Project Name: **HOFFMANTOWN WEST CHURCH**

Martin Chavez, Mayor
Interoffice Memorandum

April 11, 2005

To: Sheran Matson, DRB Chair
CC: Claire Senova
From: Elvira Lopez, Planner
Subject: EPC Project 1002371, 04EPC-01713; DRB Project 1002371, 05DRB-00560

ENGINEER'S SEAL	HOFFMANTOWN WEST CHURCH	DRAWN BY BJF
	PRELIMINARY GRADING PLAN	DATE 06-20-05
	TERRA WEST, LLC 8509 JEFFERSON NE ALBUQUERQUE, NEW MEXICO 87113 (505)858-3100	2380GRB-04-28-05x
		SHEET # C2
RONALD R. BOHANNAN P.E. #7868		JOB # 230080

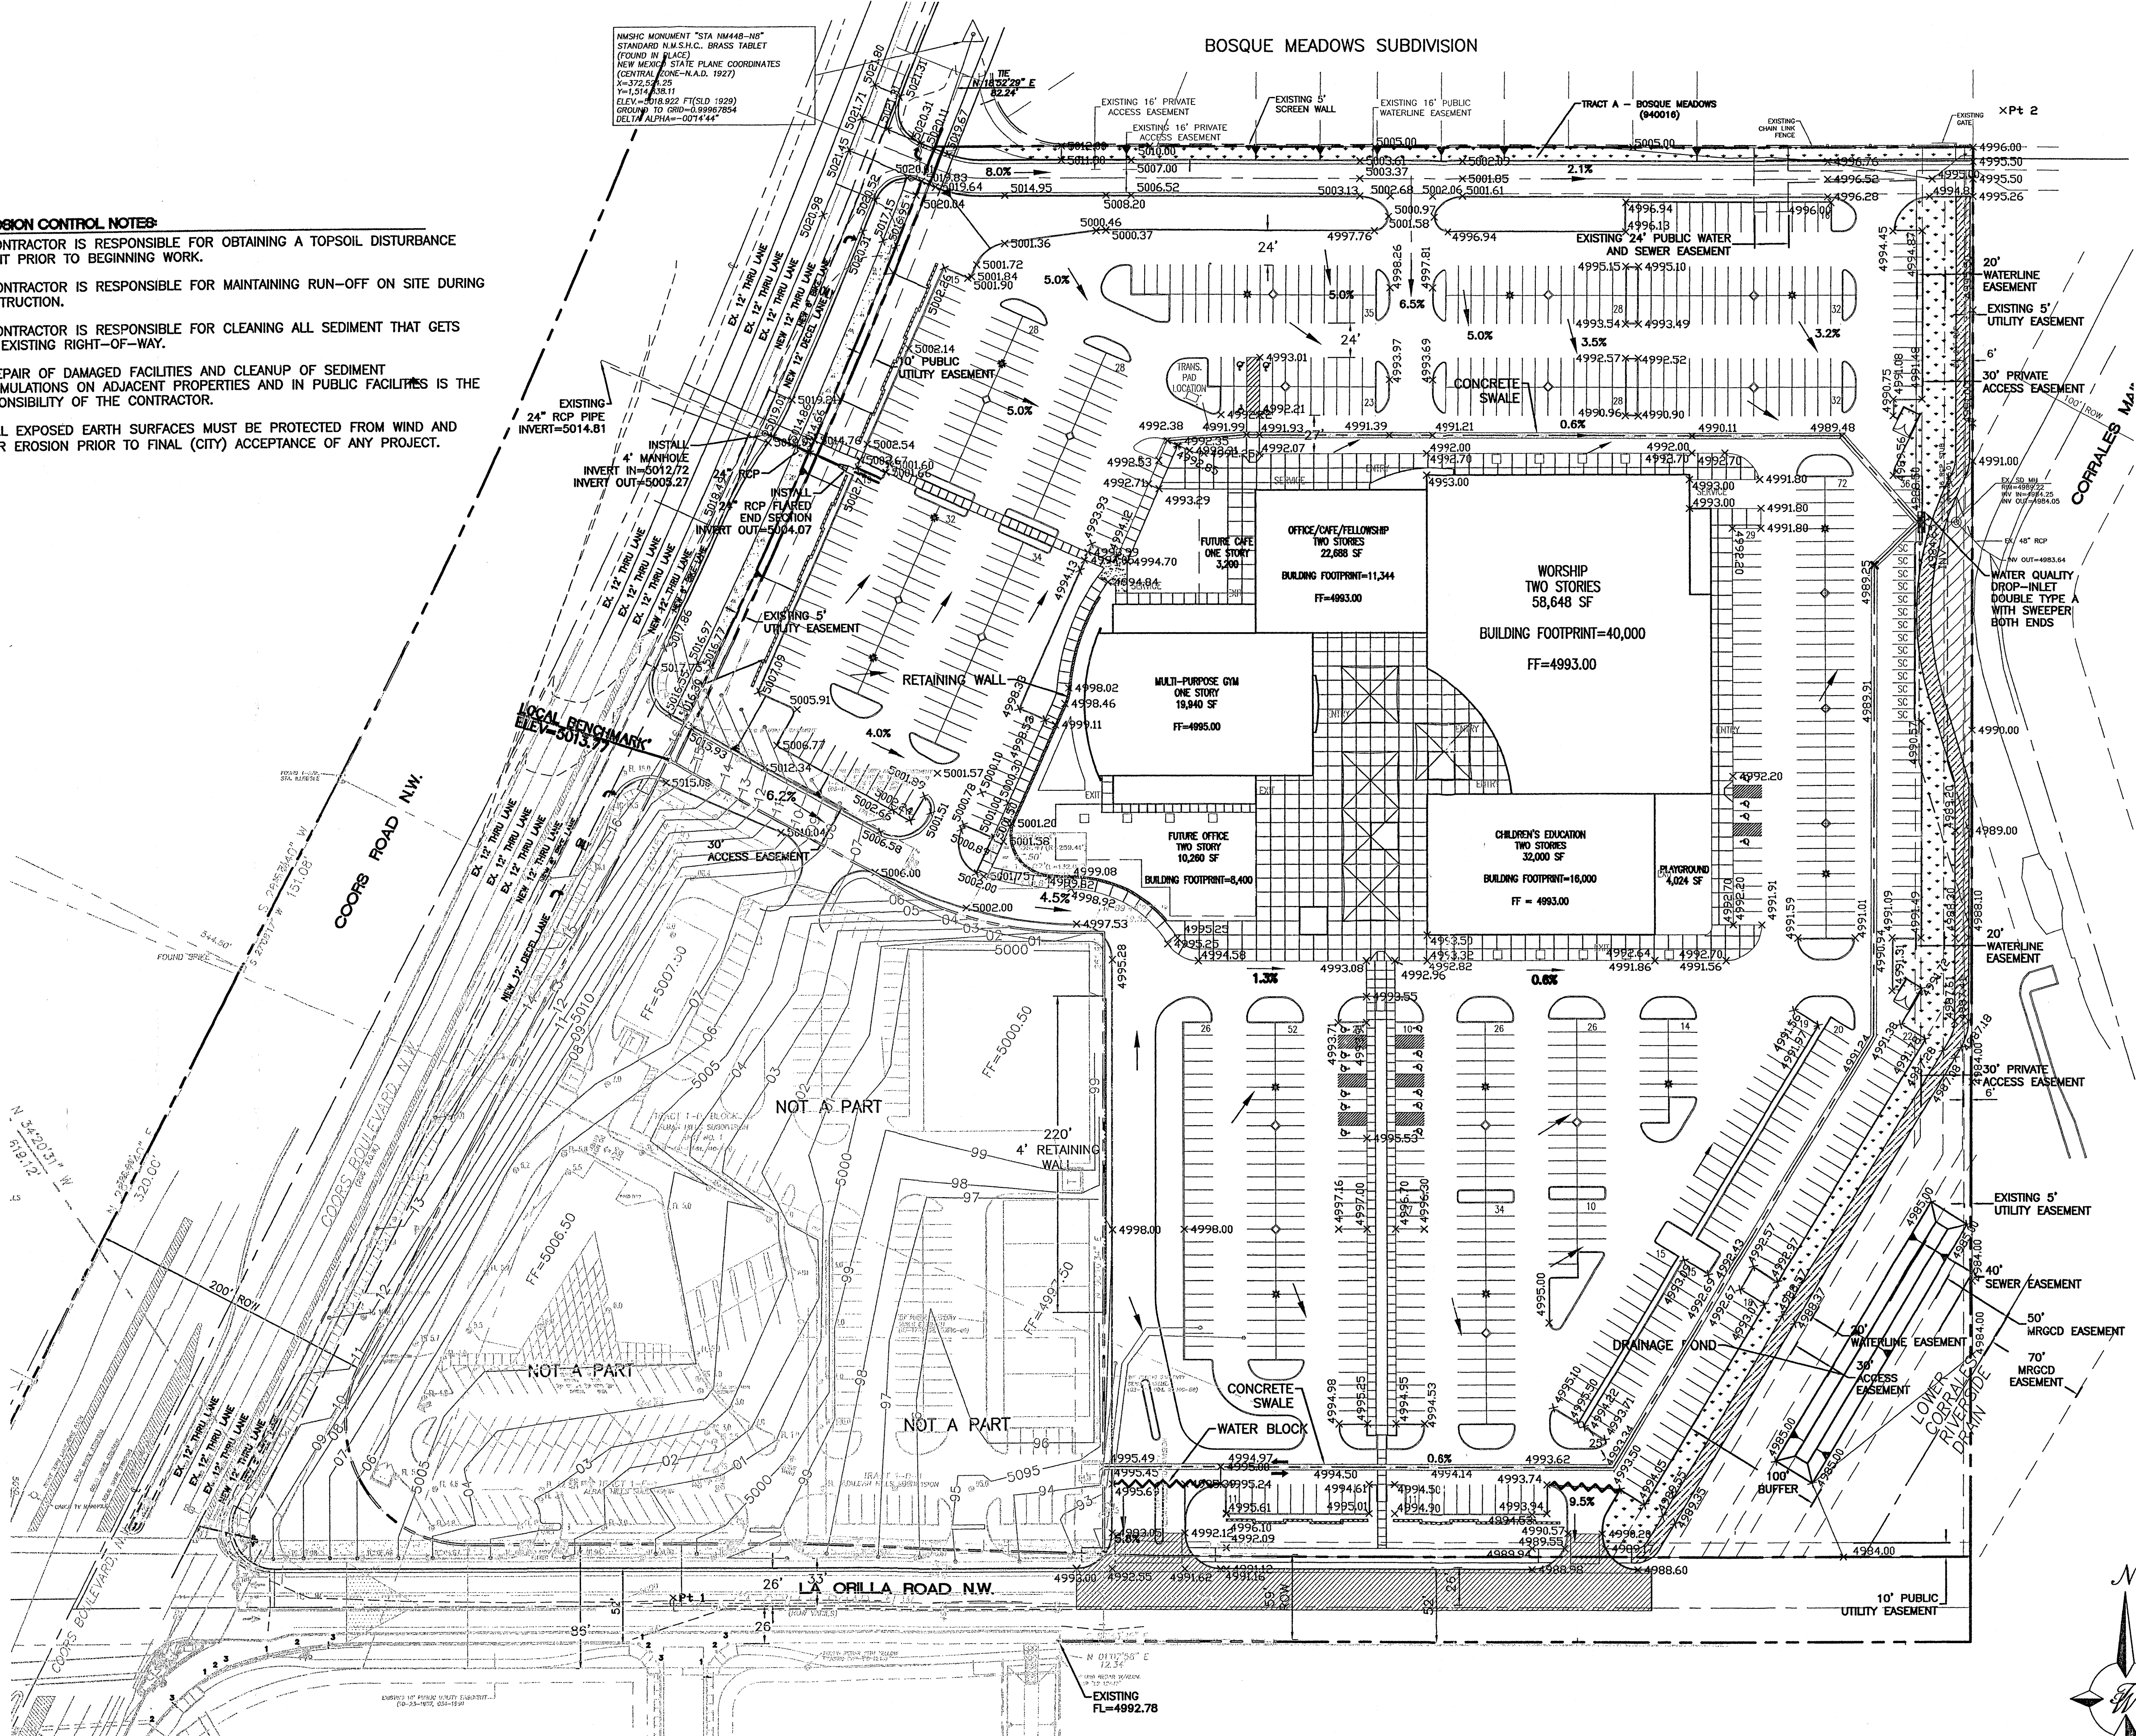
Staff found that the retaining wall along the eastern boundary is no longer shown on the conceptual grading and drainage plan. Is there a reason for removing this wall?

REVISIONS
DATE JUNE 20, 2005
NORTH SCALE 1/8"=1'-0"
DRAWING NAME SCHEMATIC ELEVATIONS
SHEET NUMBER C6

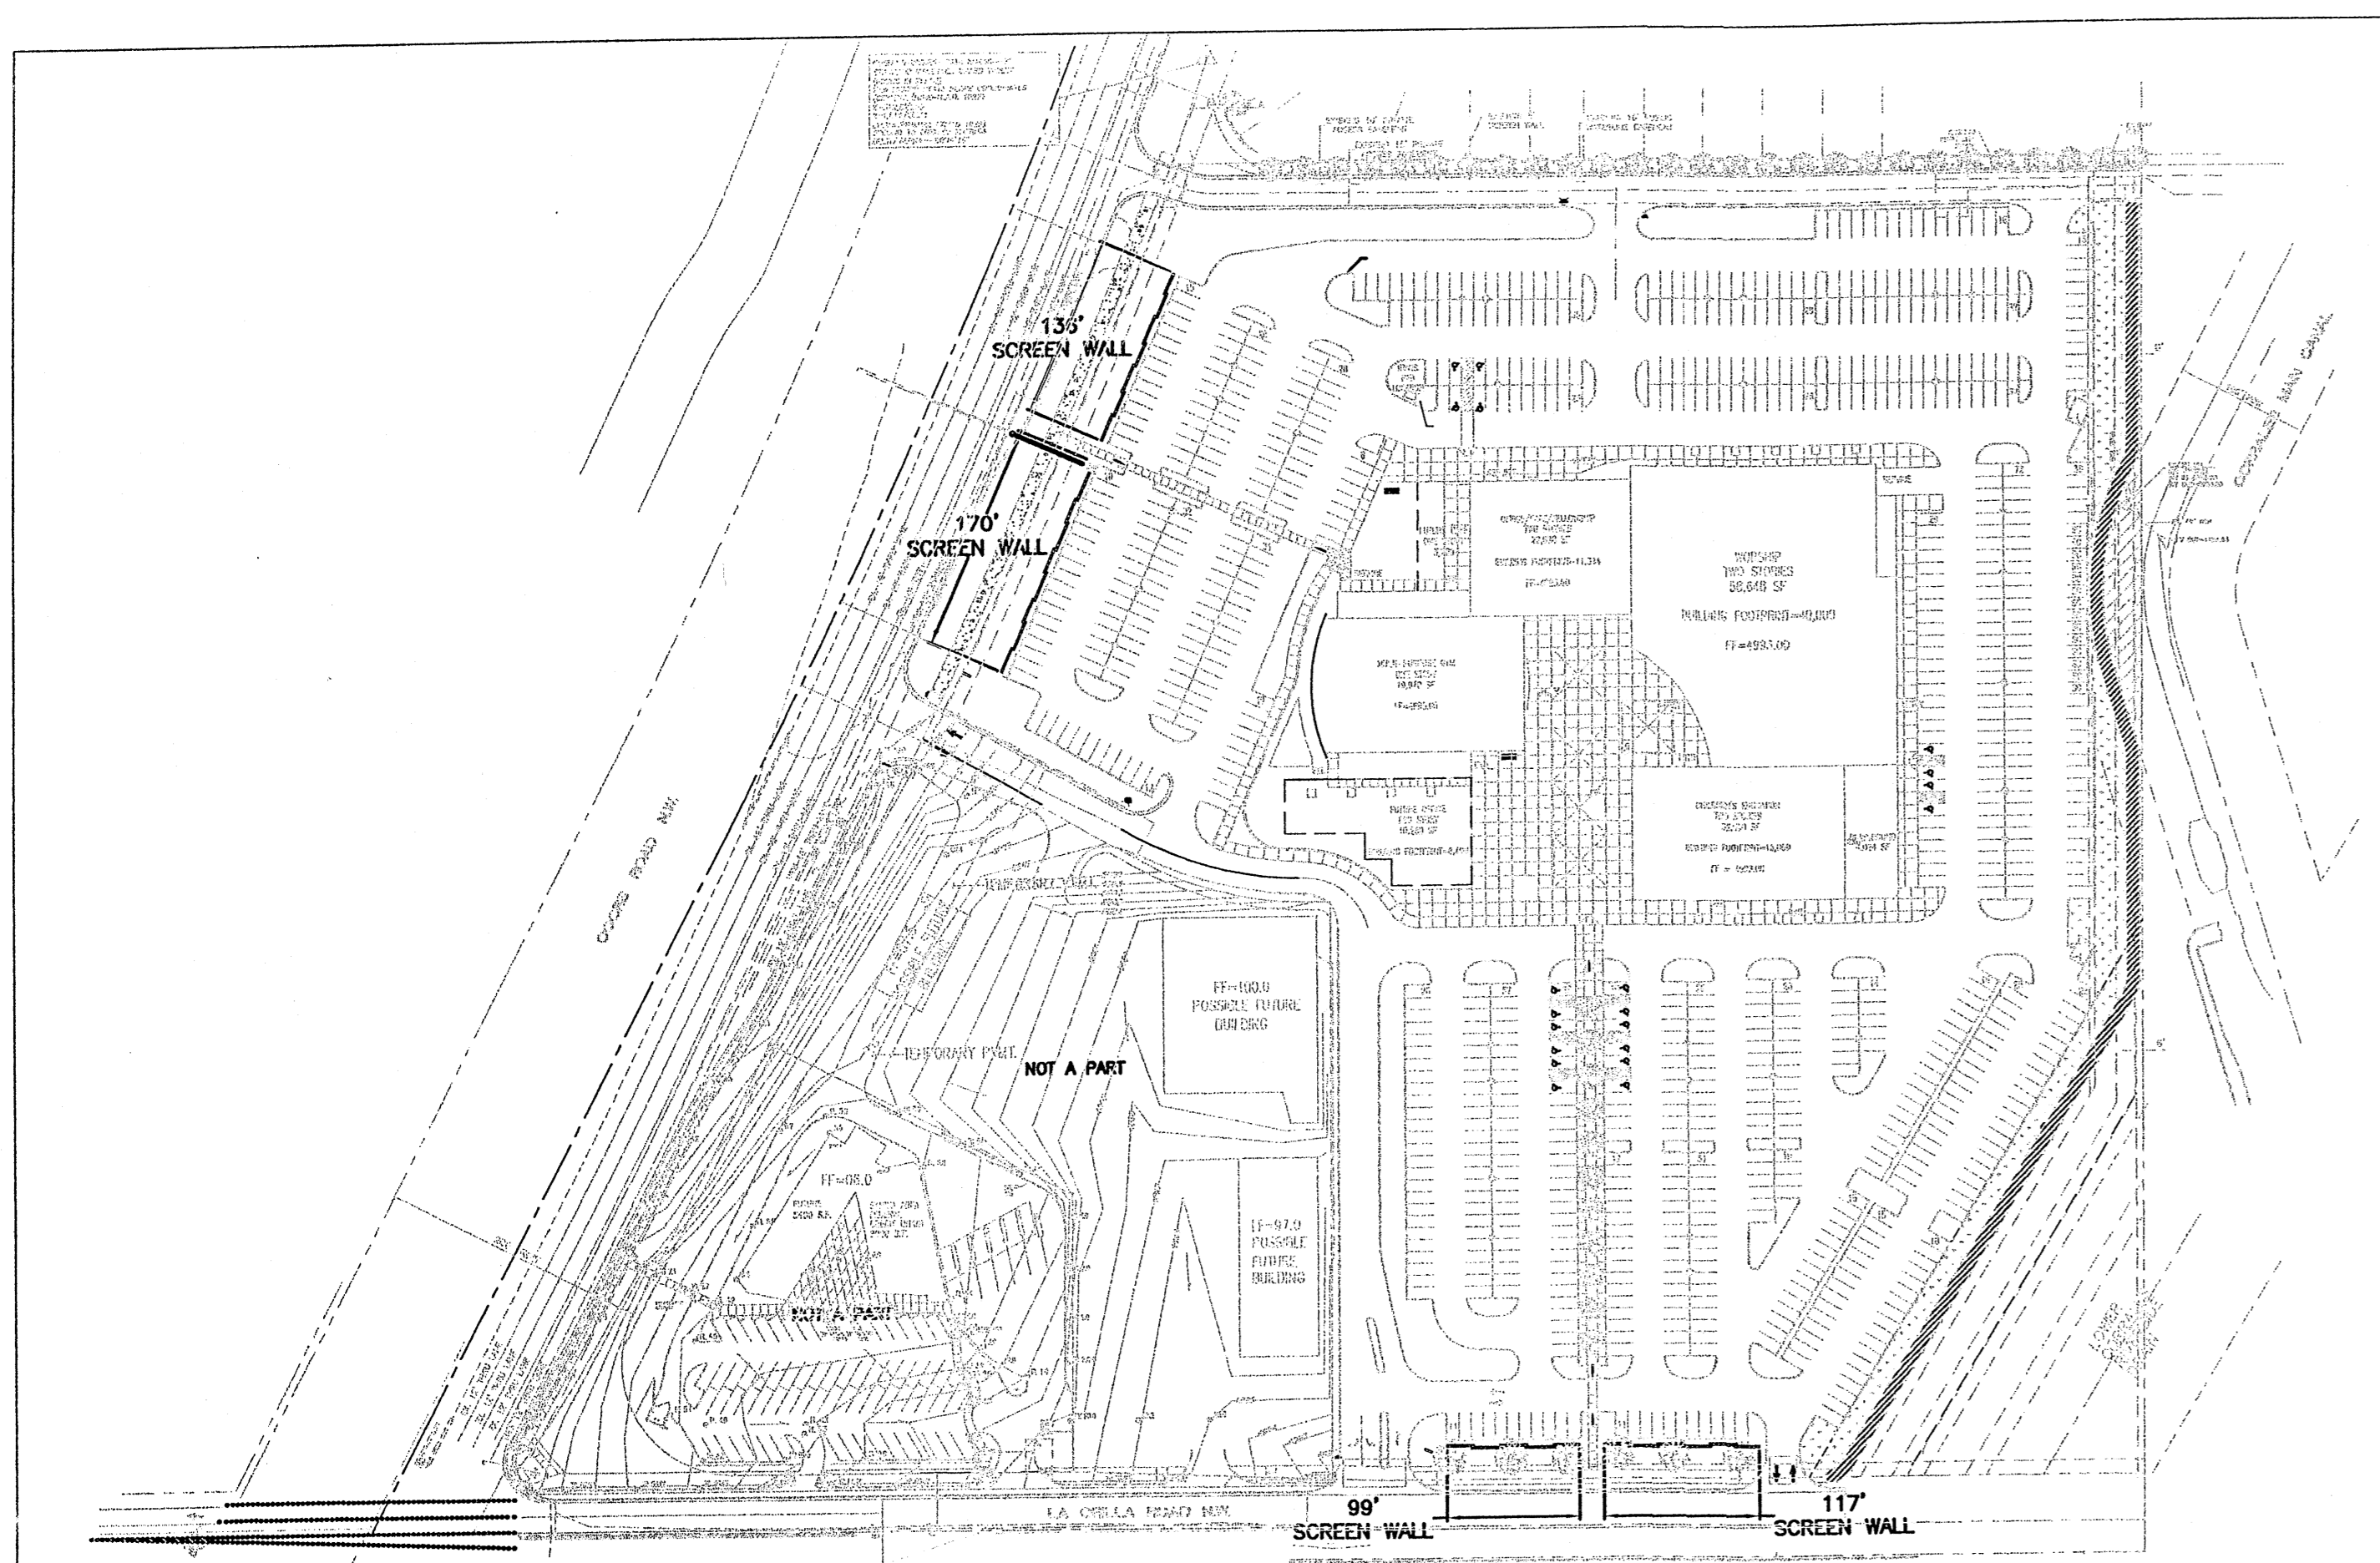
12e. Condition met, but sheet C6 indicates that reveals along the West Elevation (south) have recesses that are 1" wide. Staff measured the width of these reveals that appear to be 1' wide. Please verify and correct.

RETAINING WALL DETAIL

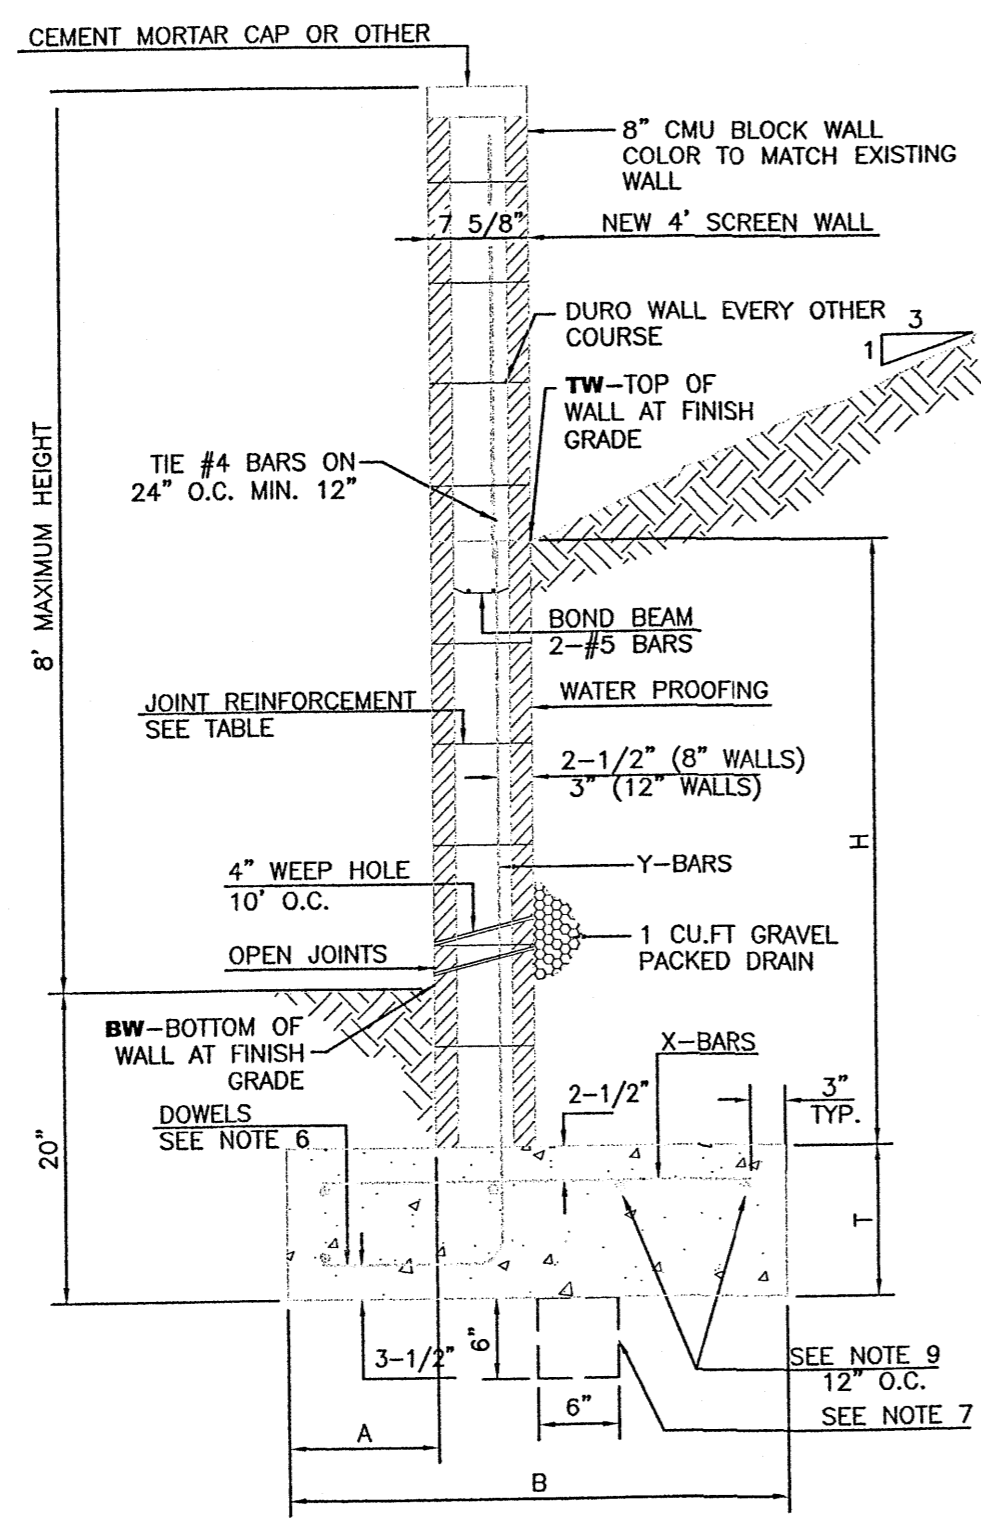
6b. Unclear. Staff is unclear about the referenced **perimeter wall sheet** is located. Staff notes that there is a retaining wall detail on sheet C7.
